2024 No. 446

**The Immingham Open Cycle Gas Turbine (Amendment) (No. 2)
Order 2024**

Amendment to Schedule 12 (design parameters)

3. For the table in Schedule 12, substitute—

Schedule 12 dimension changes highlighted in blue

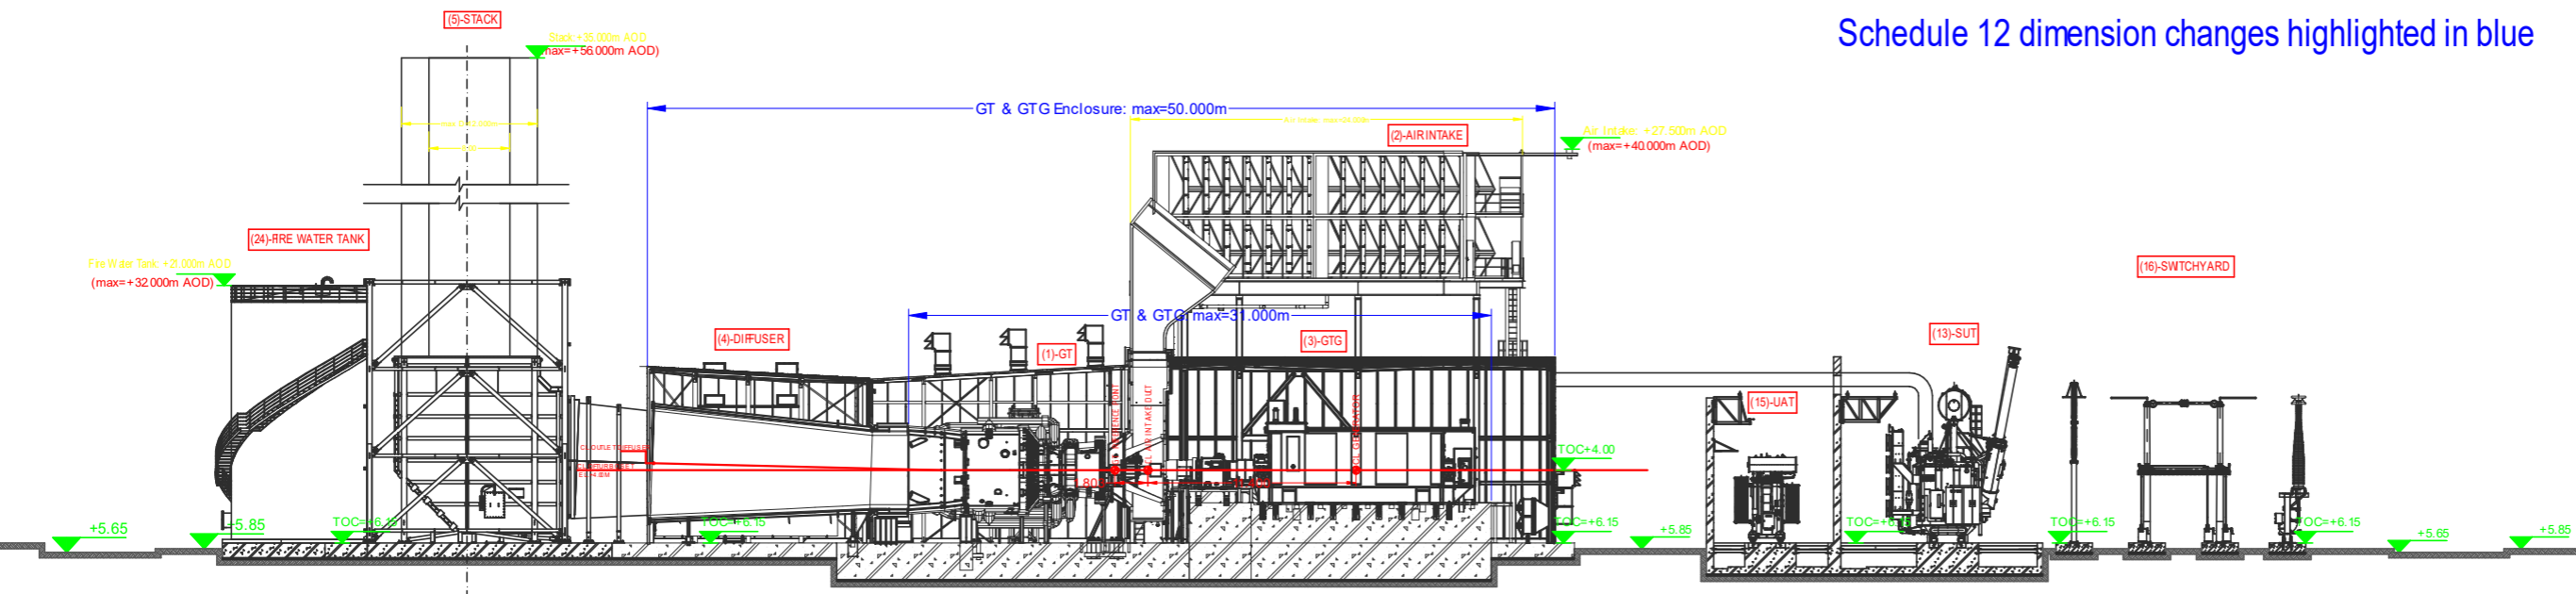
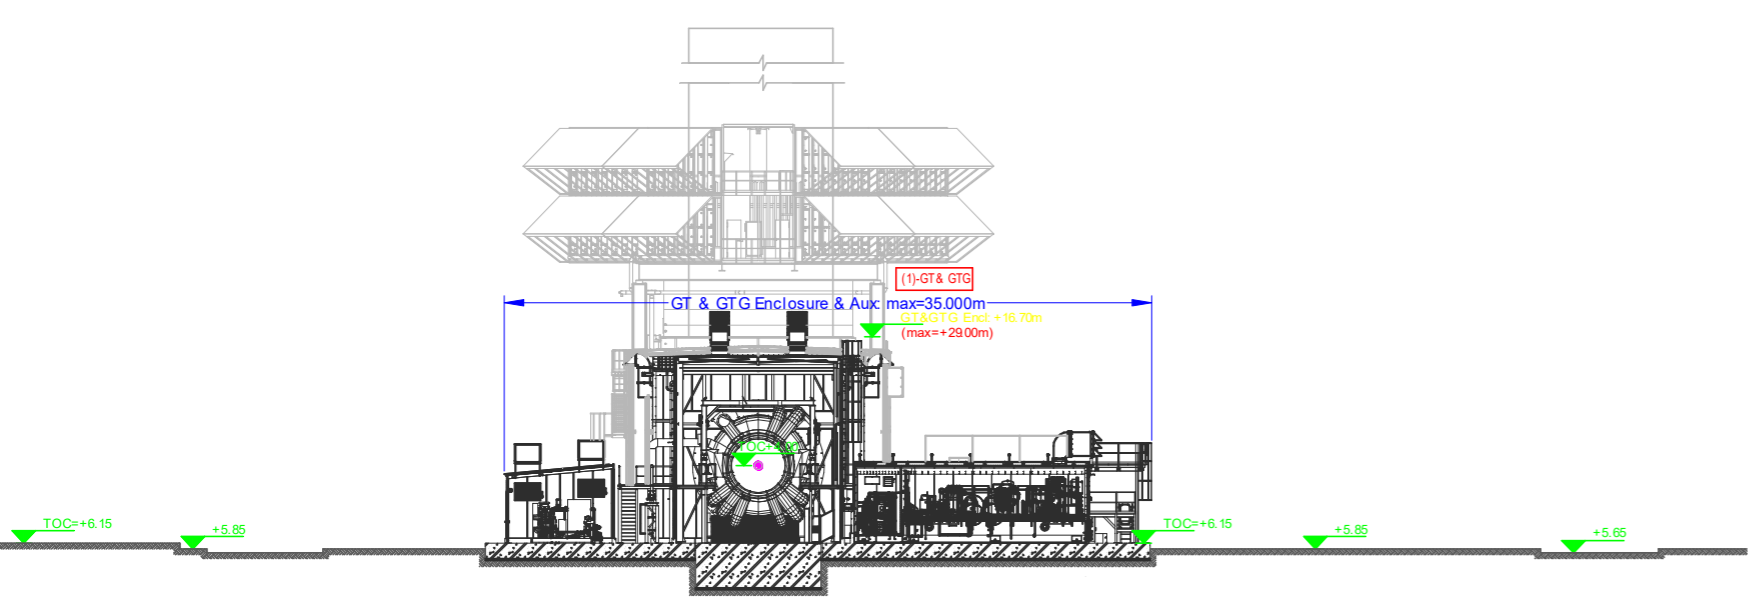
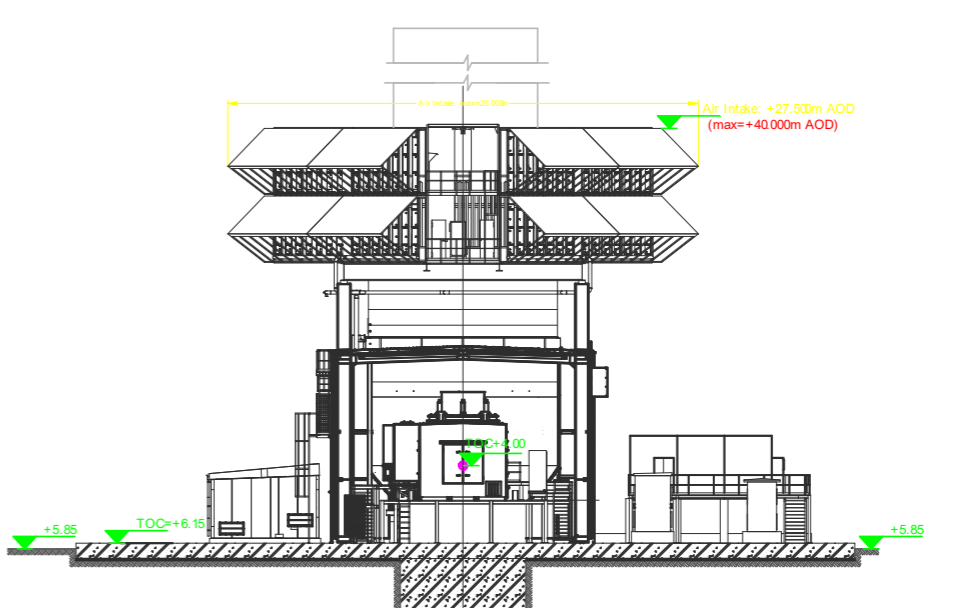
<i>(1) Building or structure</i>	<i>(2) Maximum length (metres)</i>	<i>(3) Maximum width (metres)</i>	<i>(4) Maximum height (metres above 0 meters above ordnance datum)</i>	<i>(5) Maximum diameter (metres)</i>
Single gas turbine and generator	31	20	20	-
Gas turbine building	50	35	29	-
Exhaust stack	-	-	56	12
Air intakes	24	16	40	-
Fin-fan cooler	30	15	17	-
Control room, workshops, stores	35	20	16	-
Demineralised tank, firewater tank	-	-	32	24”
